From: Contact Centre (CRM) <contact@ribblevalley.gov.uk>
Sent: 06 March 2023 21:01
To: Planning
Subject: Planning Application Comments - 3/2023/0107 FS-Case-494146746

Planning Application Reference No.: 3/2023/0107

Address of Development: Overdale, York Lane, Langho BB6 8DT

Drawing title  
Proposed Floor Plans and Elevations

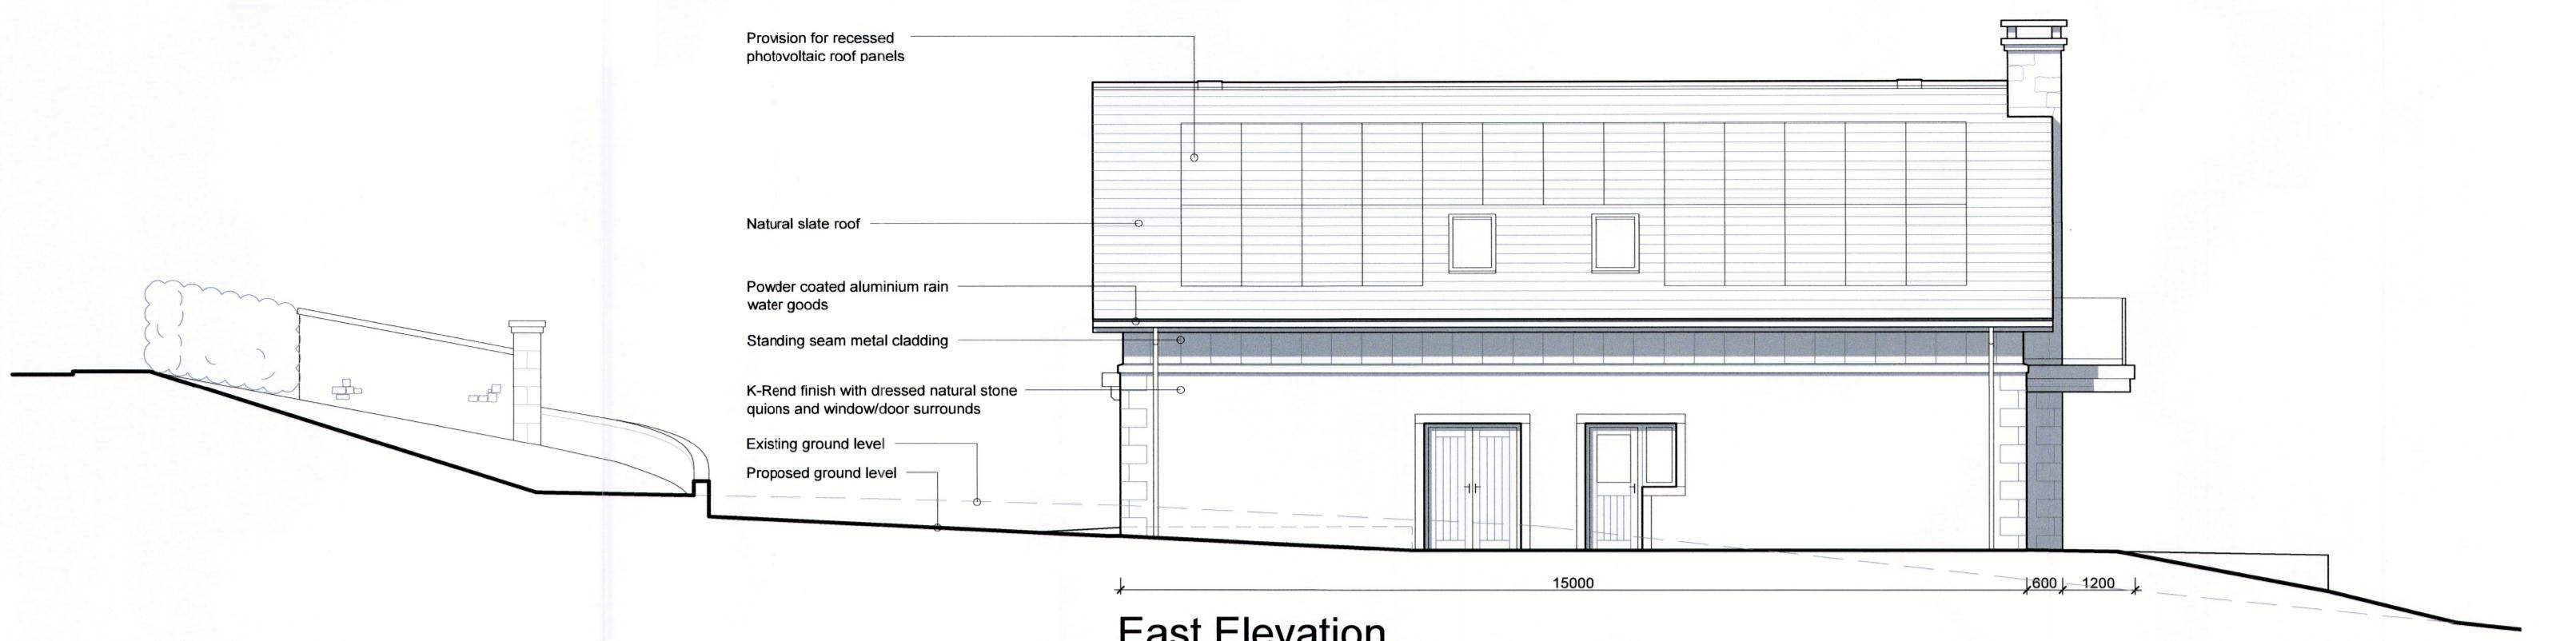
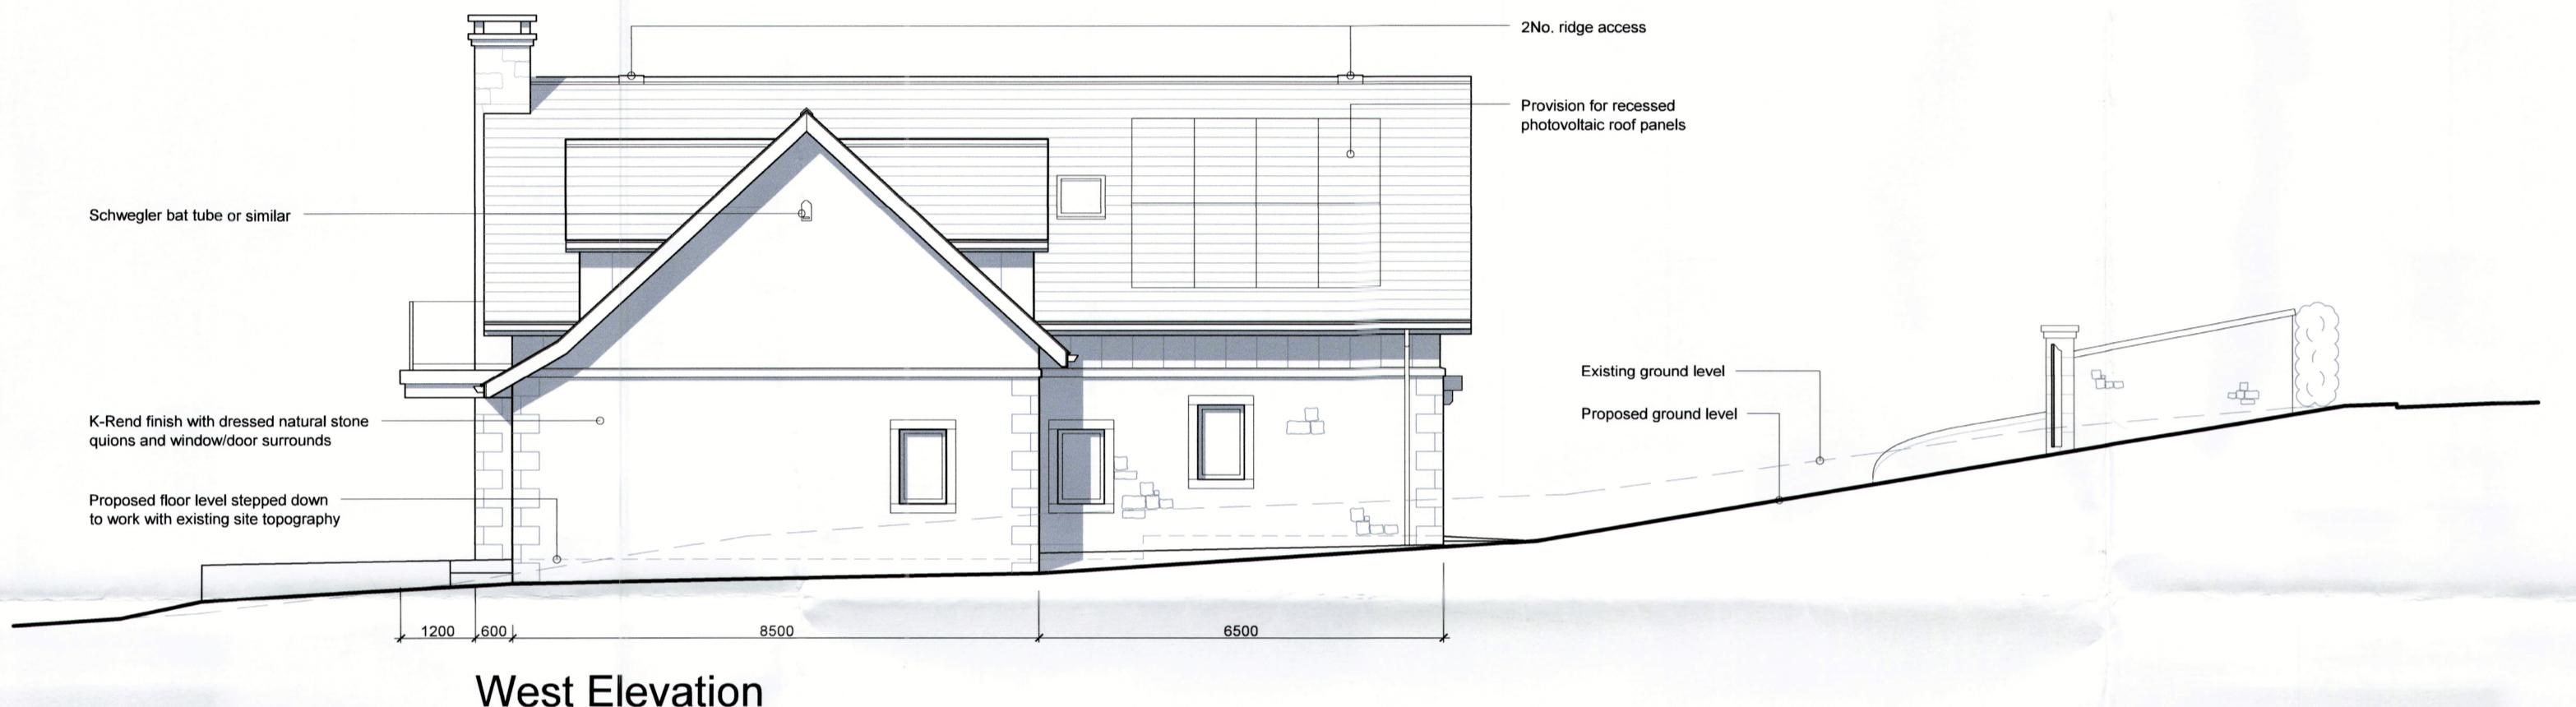
The proposed pitch height is significantly higher than the current property. The previously approved plan (3/2020/1103) had a building that was set back (further away from York Lane) and the build started at a much lower level, to minimise the loss of light to surrounding properties. This proposal will have an [REDACTED]

If the proposed property is 2 floors, the building must be set further back on the site and the ground height should be lower to minimise the impact of reduced light [REDACTED]
